Rezoning Transportation Analysis
Petition Number: Insert Zoning Petition #2021-199
General Location Identifier: Tax ID 08307315

Date	Description
12-28-2021	First Review (AO)
01-25-2022	Second Review (AO)

SHEET NO.: **RZ-1**

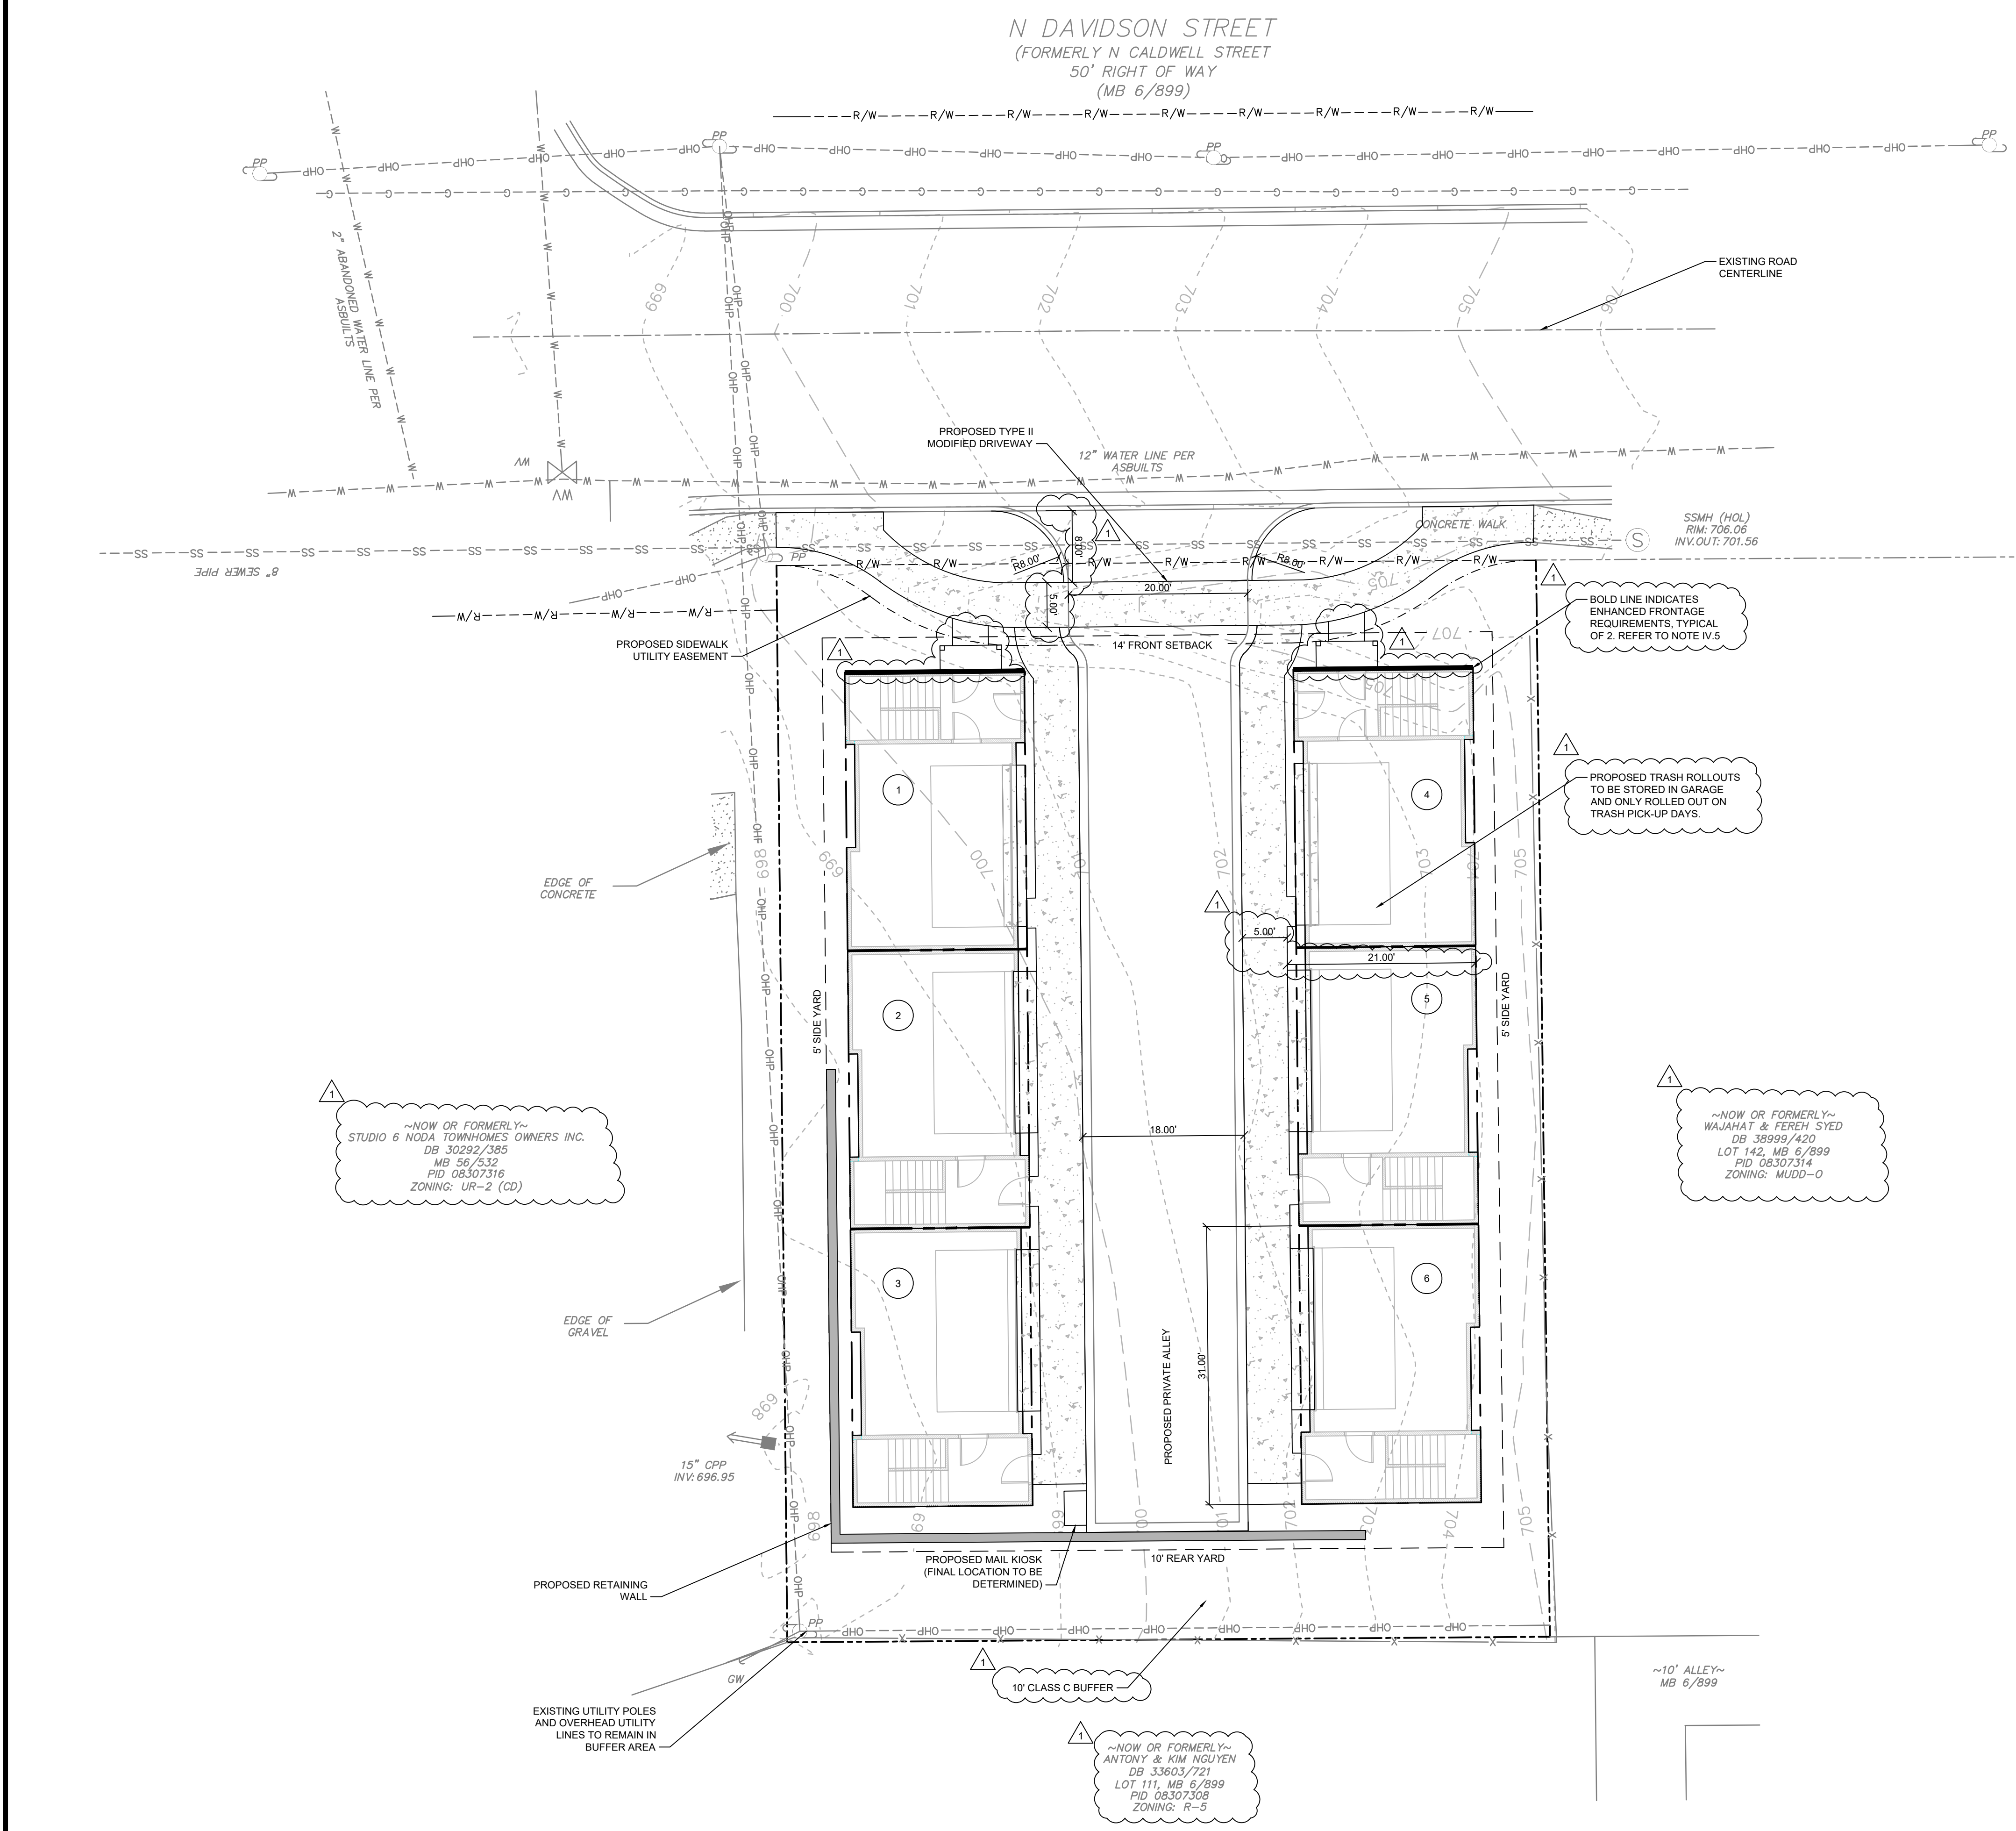
1. **Curbline:** The proposed zoning district has a setback measured from back of the existing or proposed future curbline.
 - a. **N Davidson St:** Distance from centerline to back of curb: 24'

Label and dimension the curb and gutter from the centerline for each road on the site plan.

3. **Outstanding Comment from 12-28-21:** Revise site plan and conditional note(s) to commit to dedicate 35' of right-of-way from the road centerline. The site plan shall label and dimension the right-of-way from the road centerline.
4. **Outstanding Comment from 12-28-21:** Revise site plan and conditional note(s) to commit to construct an 8-foot planting strip, and 8-foot sidewalk on N Davidson St per Chapter 19 & Chapter 20. The site plan shall label and dimension both items from the back of curb and gutter and road centerline.
5. **Outstanding Comment from 12-28-21:** The proposed dwelling units exceeds 12 per acre. Per Chapter 20 Subdivision ordinance, site plan and conditional note(s) revisions are needed to commit to construct an 8-foot planting strip, and 8-foot sidewalk along N Davidson St. The wider sidewalk also meets the Charlotte WALKS Policy.

- 6. **Outstanding Comment from 12-28-21:** Revise site plan to show maintaining planting strip along entire frontage and square off sidewalk. Maintain consistent 2' Sidewalk Utility Easement behind the back of sidewalk.

- 7. **Outstanding Comment from 12-28-21:** Revise site plan to show correct dimension for minimum driveway width per CLDSM 10.25E for Type II Modified Driveway based on operation and radius.
- 8. **Outstanding Comment from 12-28-21:** A site plan note(s) specifying dedication and fee simple conveyance of all rights-of-way to the City before the site's first building certificate of occupancy is issued is needed. CDOT requests rights-of-way set at 2' behind back of sidewalk where feasible.
- 9. **Outstanding Comment from 12-28-21:** A site plan note specifying that all transportation improvements will be approved and constructed before the site's first building certificate of occupancy is issued is needed. The petitioner may phase transportation improvements if said improvements and phasing are explicitly described in site plan notes.
